Recommendation Report for Planning Permission for Works or Extension to a Dwelling

REF NO: FP/35/20/HH

LOCATION: 99 Flansham Park
Felpham
PO22 6RB

PROPOSAL: Single storey rear extension, extension to existing garage and conversion of garage to habitable use.

| REV                                                                 | DRAWN | DATE | DESCRIPTION |
|---------------------------------------------------------------------|-------|------|-------------|
| Proposed Plans and Elevations                                       |       |      |             |

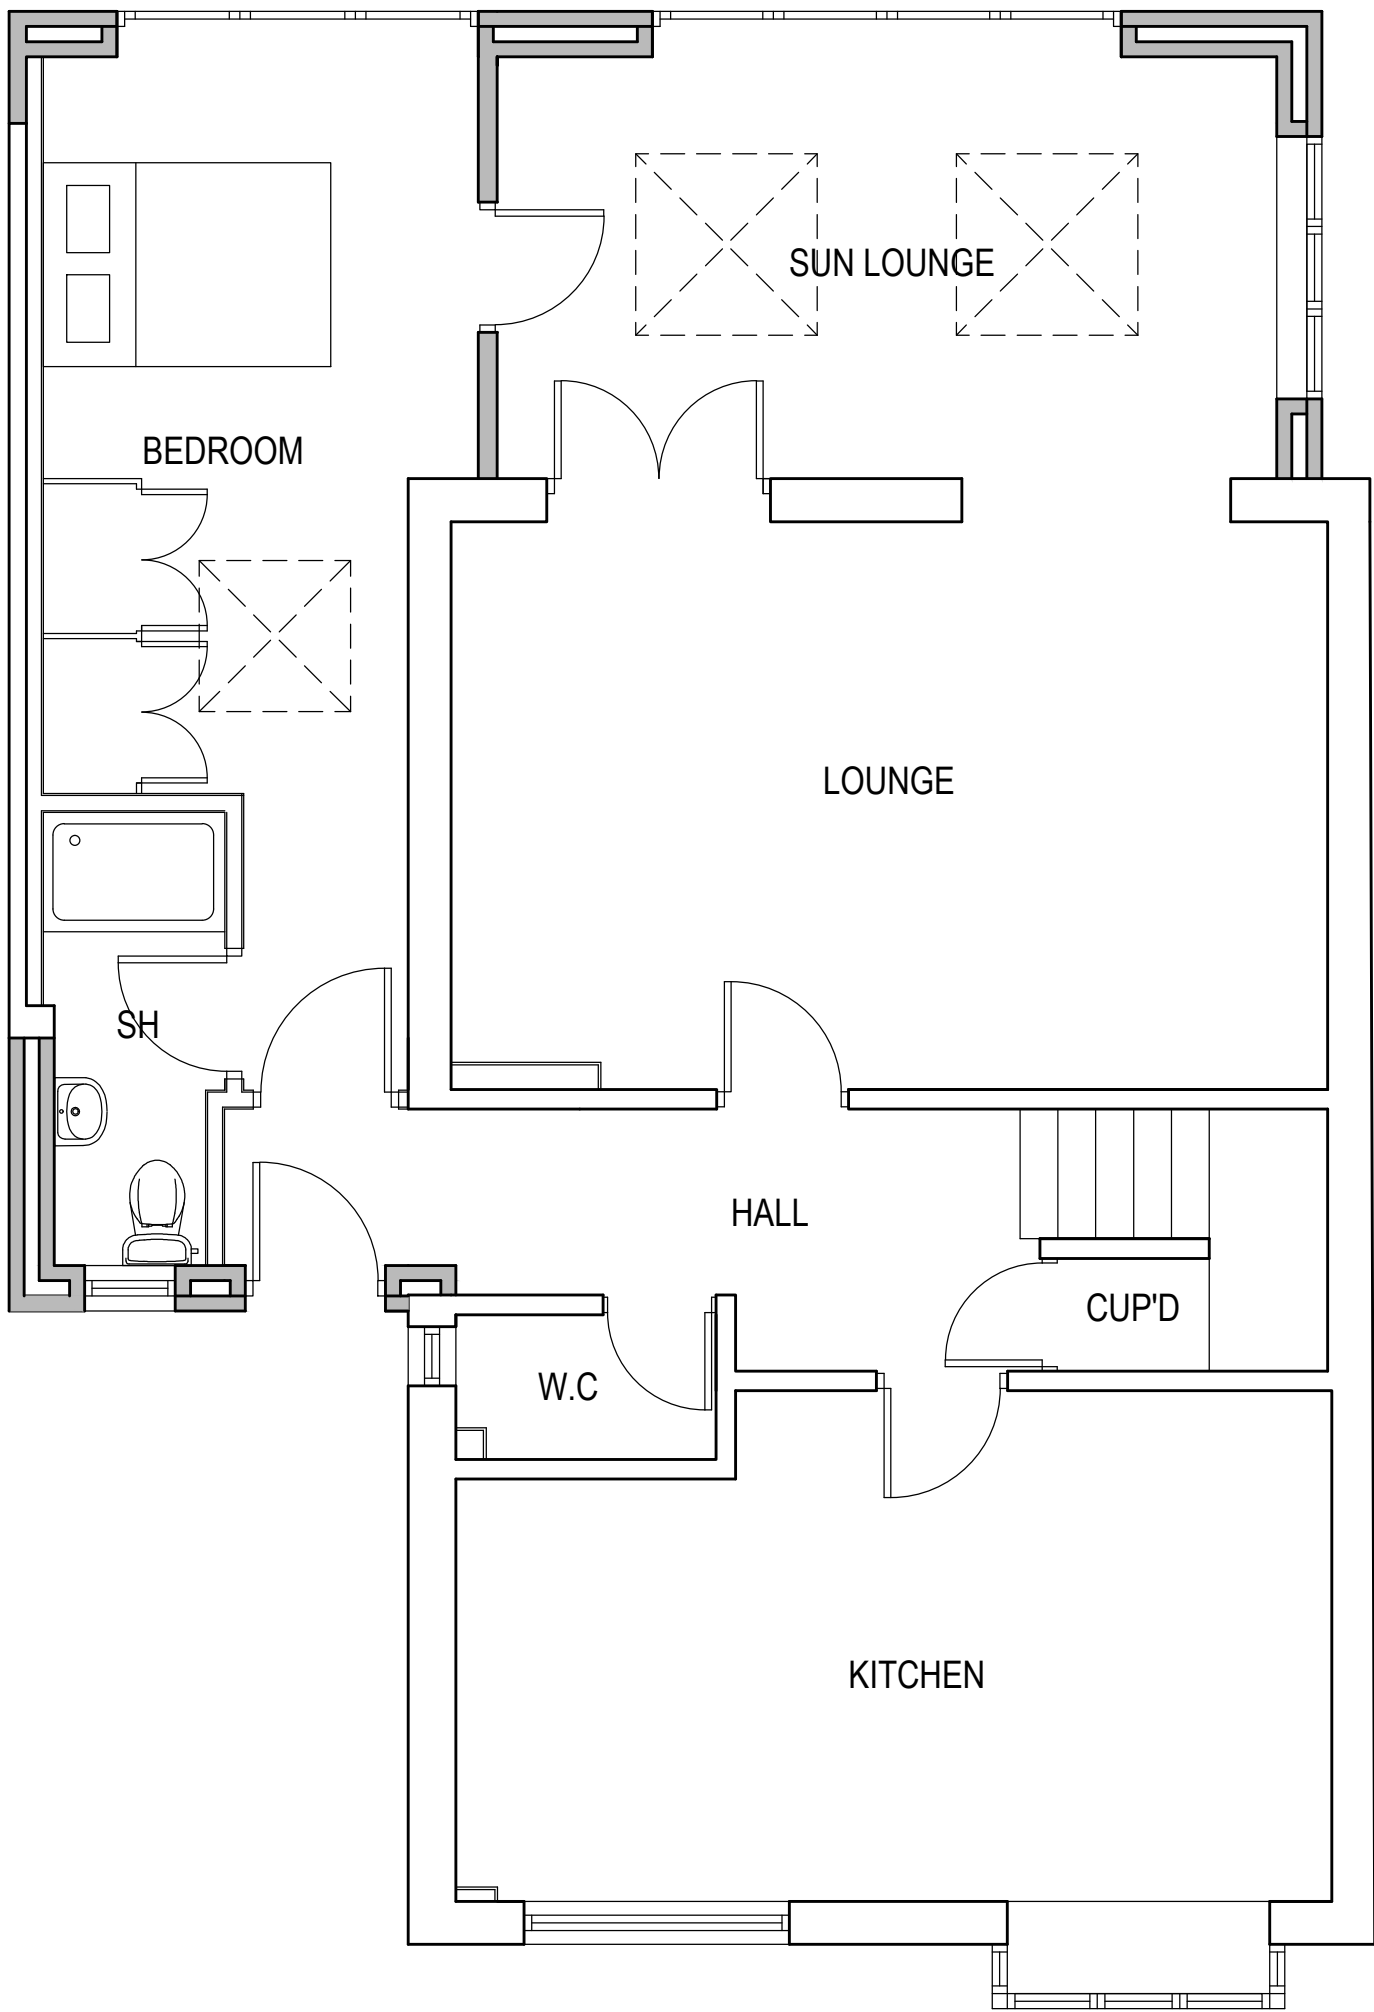
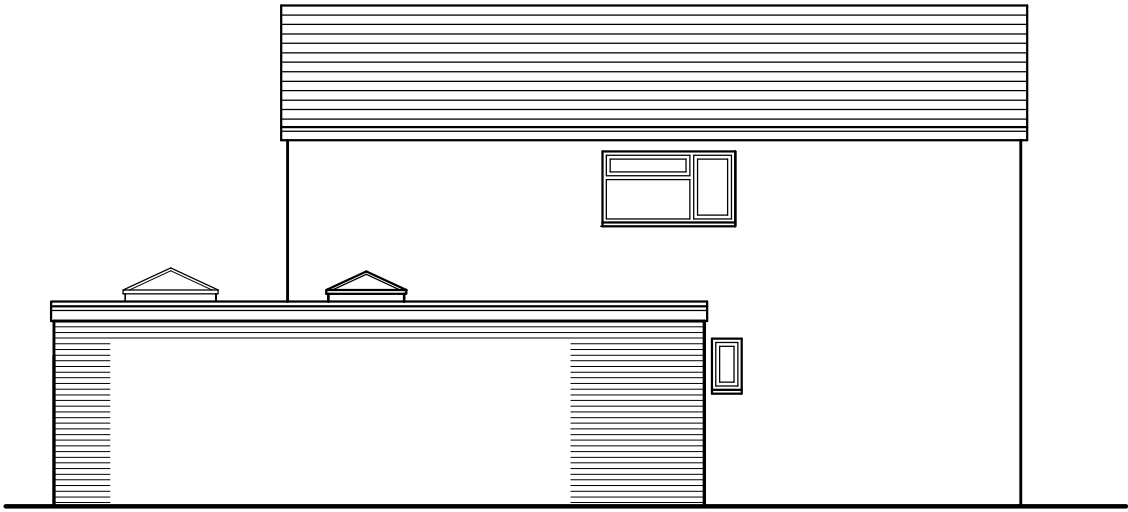
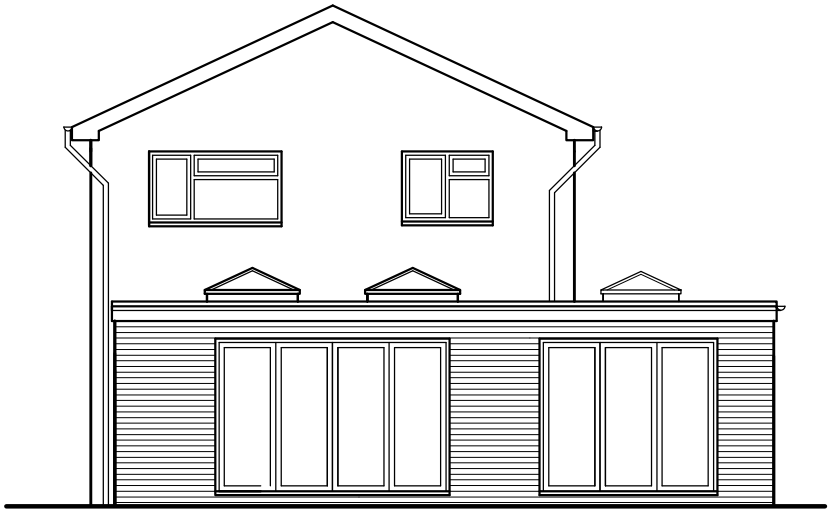
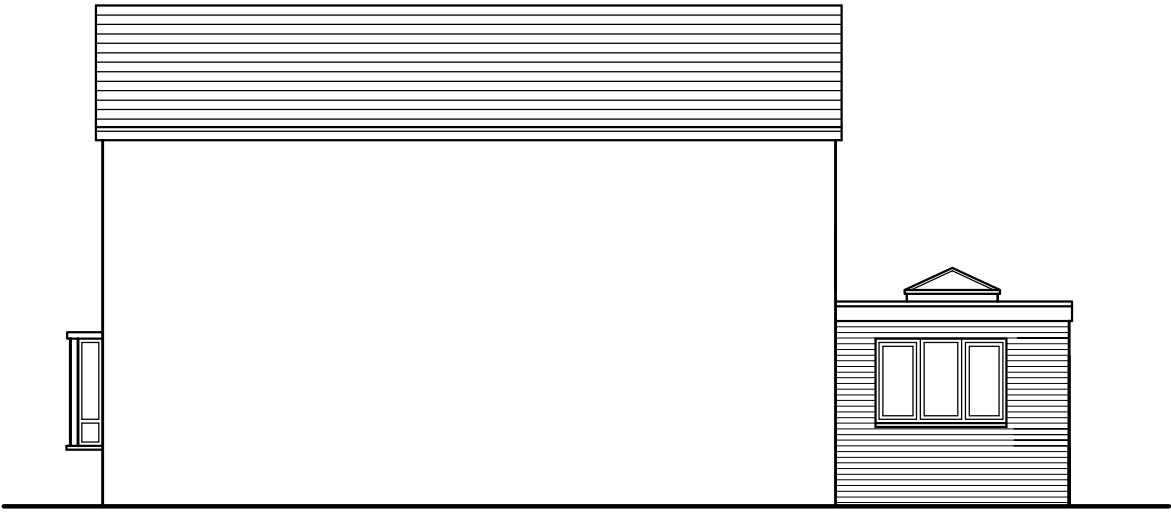
There is currently an attached garage to the northern elevation and there will be small extension to the front of this with a depth of around 1.8m. This retains 8.2m to the front boundary of the property and does not extend beyond the principal elevation.

There is currently a garage door fronting the street scene and this will alter to a door and a window as it will be converted to habitable accommodation.

To the rear of the dwelling, there is an existing conservatory which extends 3m. The existing garage also extends beyond the rear of the property by 2.6m. The development to the rear will be removed and replaced with an extension of 3m depth which will run along the full rear of the property.

The extension will have a flat roof with a height of approximately 2.7m. There will be 3 rooflights with a maximum height of 3.15m.

The extension retains 1.4m to the southern boundary and with the extension to this elevation retaining the existing depth, it is not considered to appear overbearing or overshadowing upon neighbouring amenity.

The extension to the garage at the northern elevation again is also not considered to result in adverse impacts with no windows to the neighbouring side elevation.

There will be new doors to the rear and also a window to the extension facing south. However at single storey and with the existing conservatory of glass construction, views are not considered to increase from that which are already achievable.

The alteration of the garage to habitable accommodation will result in the loss of 1 parking space. However there is sufficient space to the front of the property for approximately 2 cars and with plenty of off road parking available, the alteration is not deemed to give rise to adverse impacts upon the highway as a result.
